Recommendation Report for Planning Permission for Works or Extension to a Dwelling

REF NO: BN/136/19/HH

LOCATION: 49 Downview Road
Barnham
PO22 0EF

PROPOSAL: Part two storey part single storey rear extension and the addition of 2 x front dormers and 7 x rooflights.

PROPOSED ROOF PLAN

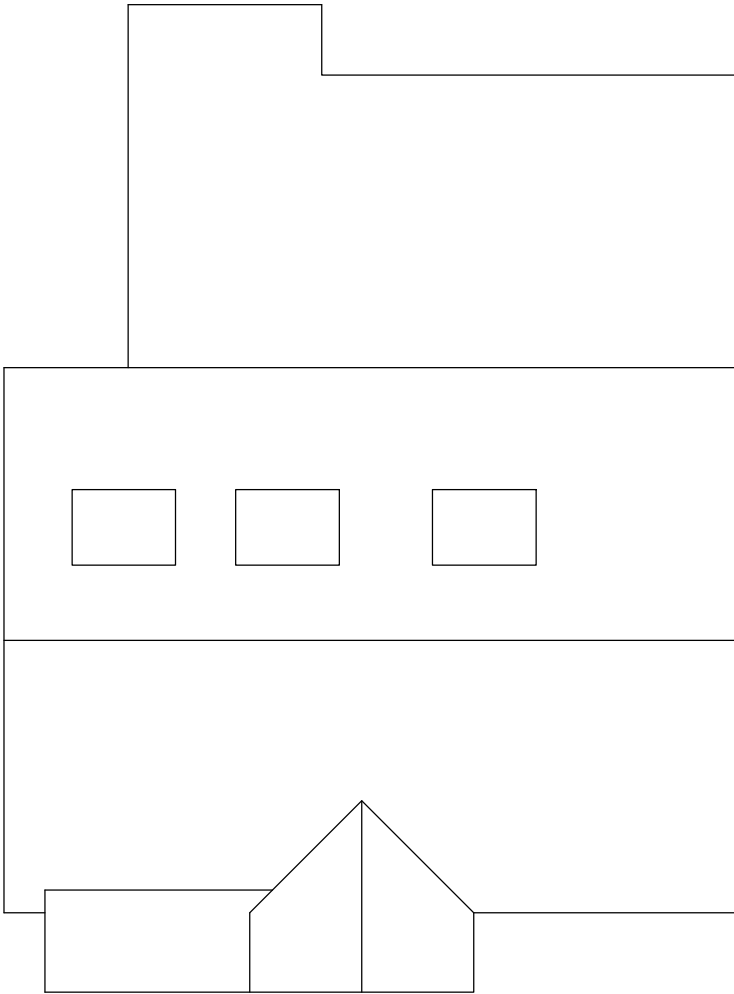
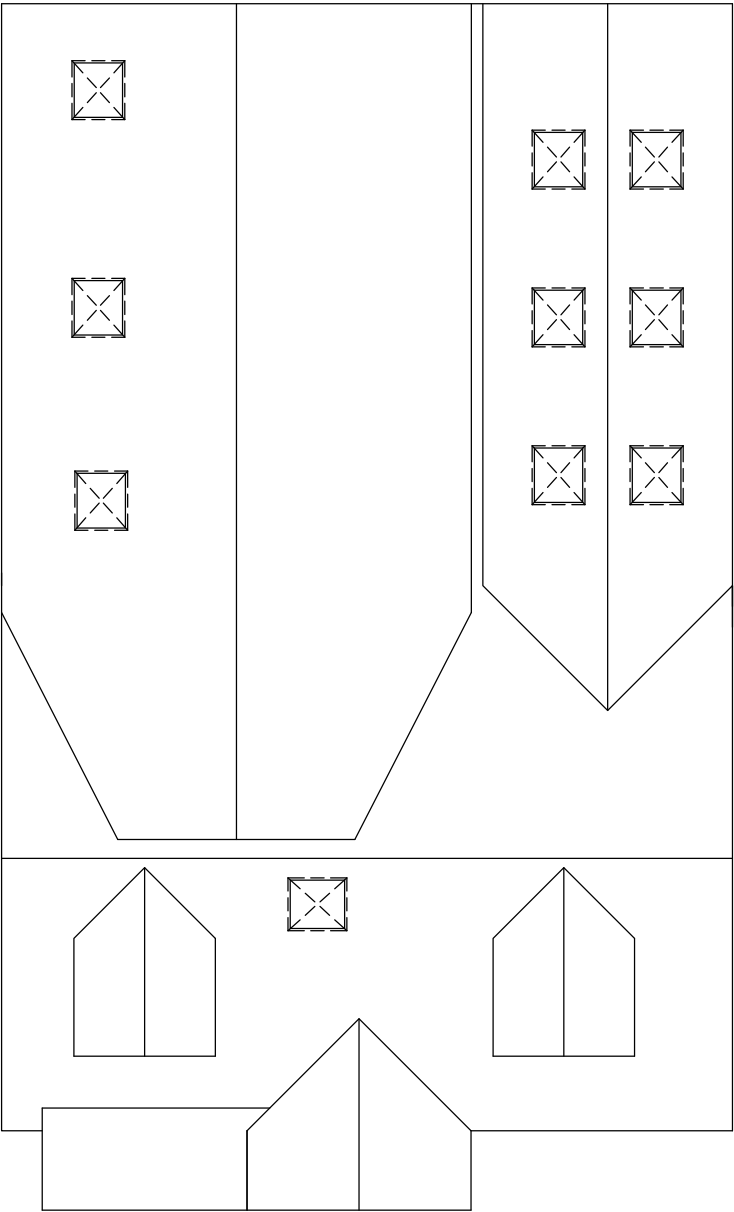
There will be a number of velux windows installed. Those to the single storey addition will be above finished ground floor level and as such will not give rise to adverse overlooking. Those to the two storey are likely to give rise to some views over the property to the north due to their siting and height. There is a conservatory/sun room to the boundary at No.48. With the neighbouring property at single storey, the two storey addition is considered to have the potential to give rise to views over No 48 and therefore the velux windows will be obscured glazed to ensure no adverse overlooking however not fixed shut.

- 3 The velux windows on the northern elevation of the building shall at all times be glazed with obscured glass.

REV.A – DORMER/VELUX MODS 15/12/19		
FOR		
MR & MRS WILLIAMS		
SITE		
49 DOWN VIEW ROAD, BARNHAM, WEST SUSSEX. PO22 0EF		
TITLE		
EXISTING DWELLING PROPOSED FLOOR PLANS		
SCALE	DRAWN	DRAWING NO.
1:100	AH 12/19	02P REV A

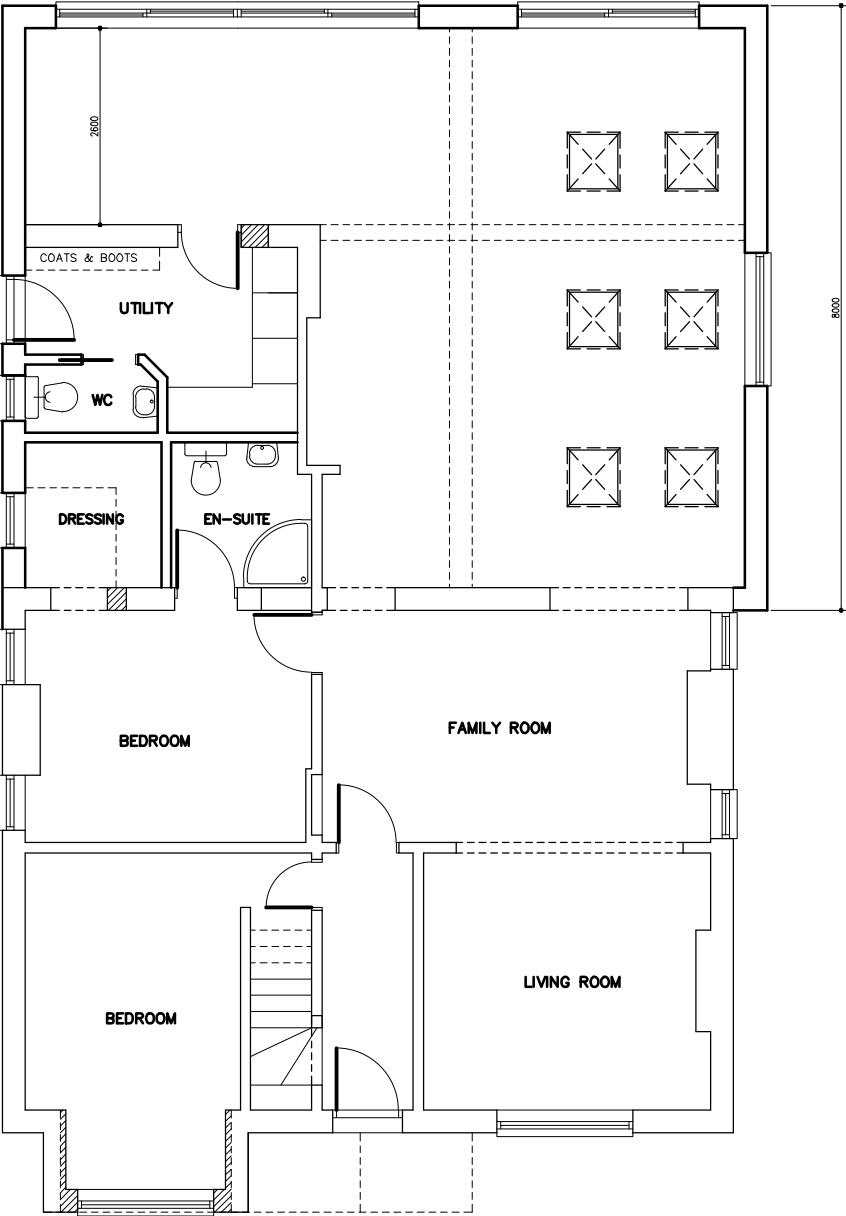
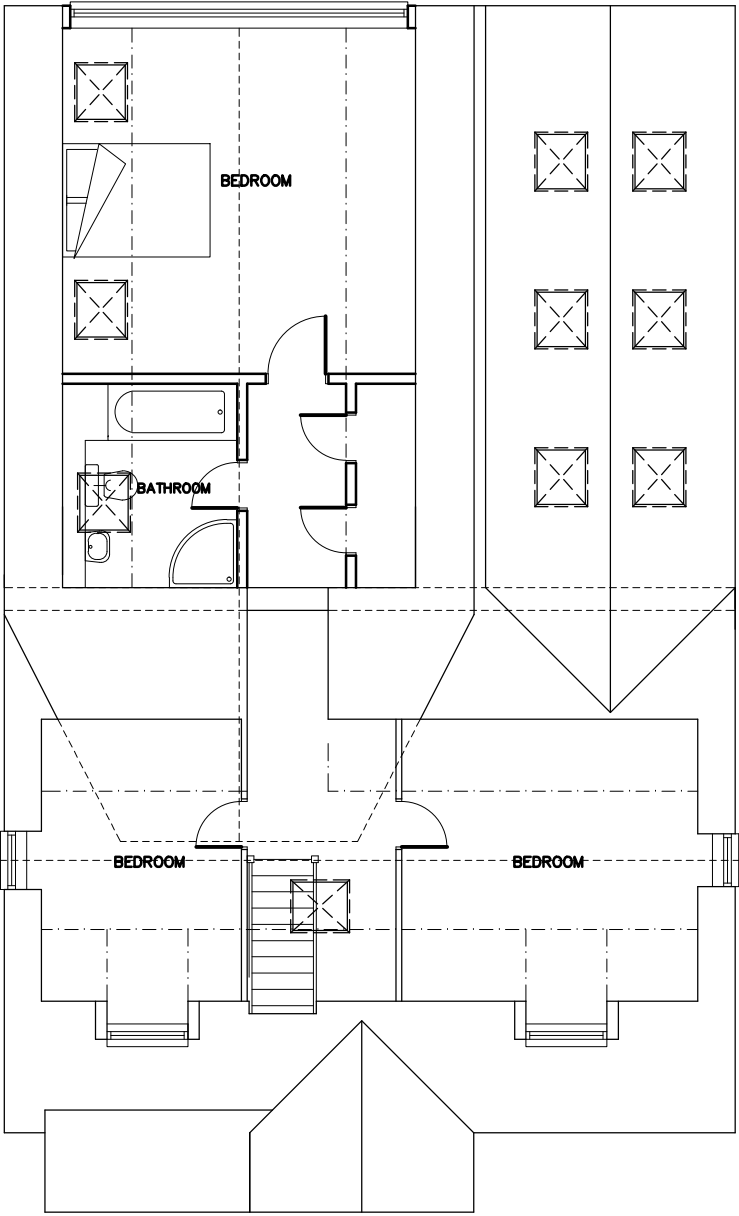
There is an existing garage door which will alter to form a window.

The alteration from a garage door will a window, will result in the loss of the garage. With sufficient room to the front garden to park 2-3 cars, it is not considered the alteration would give rise to adverse parking or highway issues.

FOR		
MR & MRS WILLIAMS		
SITE		
49 DOWN VIEW ROAD, BARNHAM, WEST SUSSEX. PO22 0EF		
TITLE		
EXISTING DWELLING		
PROPOSED ELEVATIONS		
SCALE	DRAWN	DRAWING NO.
1:100	AH 12/19	04P REV A

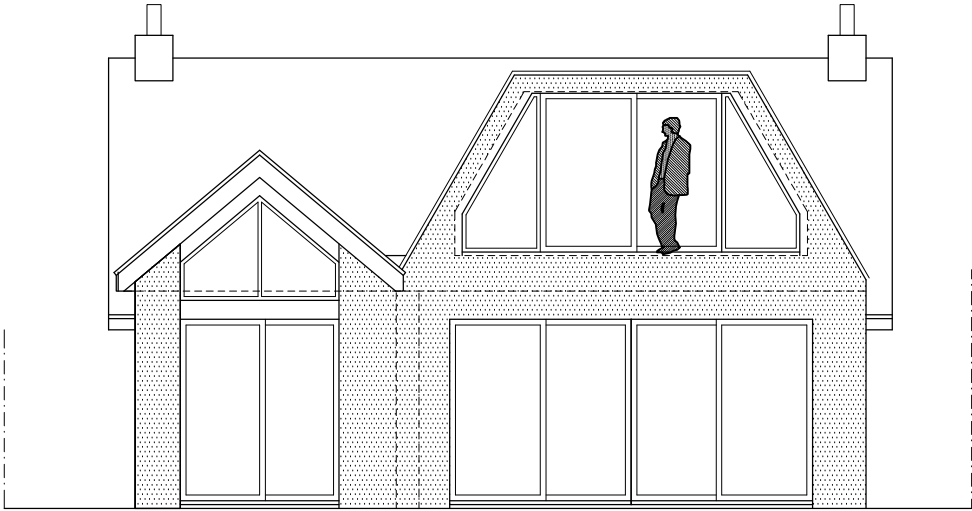
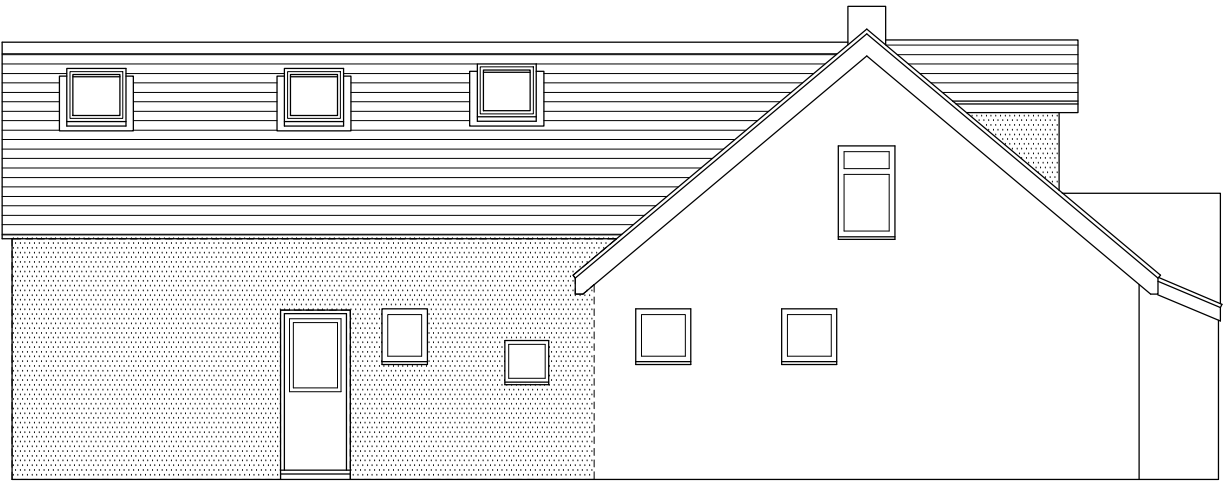
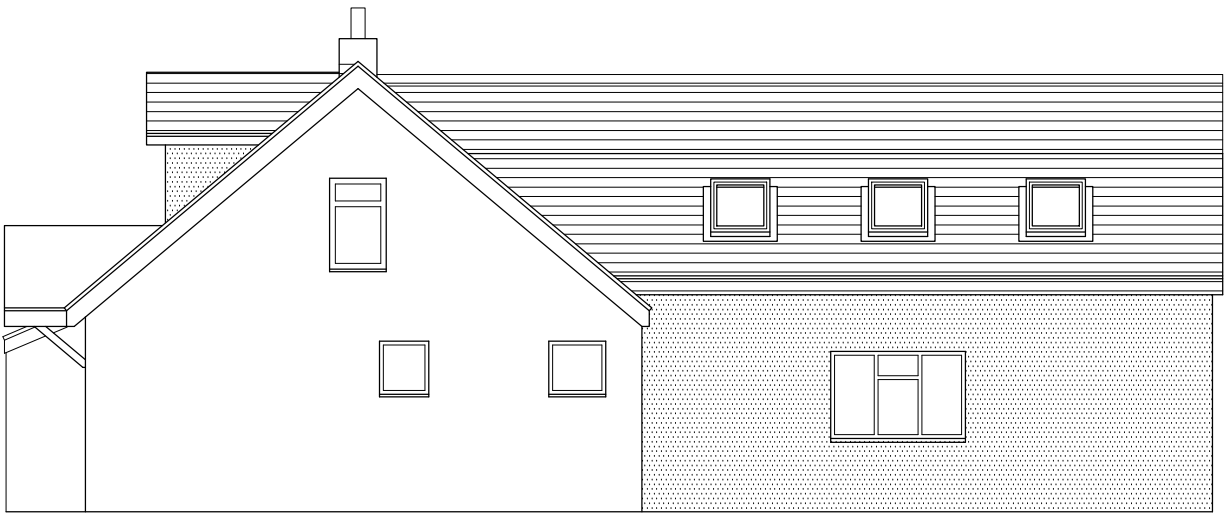
Two dormers and a velux will be constructed to the front elevation. The dormers are modest in size, with a width of 1.5m, height of 2m and a depth of 2.5m and do not appear unduly dominant upon the front roof slope.

The extension to the rear is large, however is set below the ridge height of the dwelling and considered a subservient addition. The materials proposed will match the host dwelling again ensuring it appears well integrated.

To the southern elevation the extension will be single storey with a pitched roof to a height of 4.75m and eaves to 3.1. To the northern side the height will increase to 5.7m, forming a two storey addition. This will have a flat roof however will be pitched so it leans slightly away from the neighbouring sides.

Whilst this is relatively high and extends quite far into the rear garden, there is sufficient separation to the boundaries with hedging and fencing in place, which helps to reduce any overbearing impact.

At the neighbouring property at No 48 there is a sun room to the boundary however views are already impeded by the boundary treatment. There is also a window to the rear addition however due to its siting, it is not considered to be intersected as a result of the 45 degree rule. The addition to the southern

elevation will be single storey and whilst extending further in depth is not considered to result in such adverse impacts due to overshadowing and loss of light that the application should be refused.
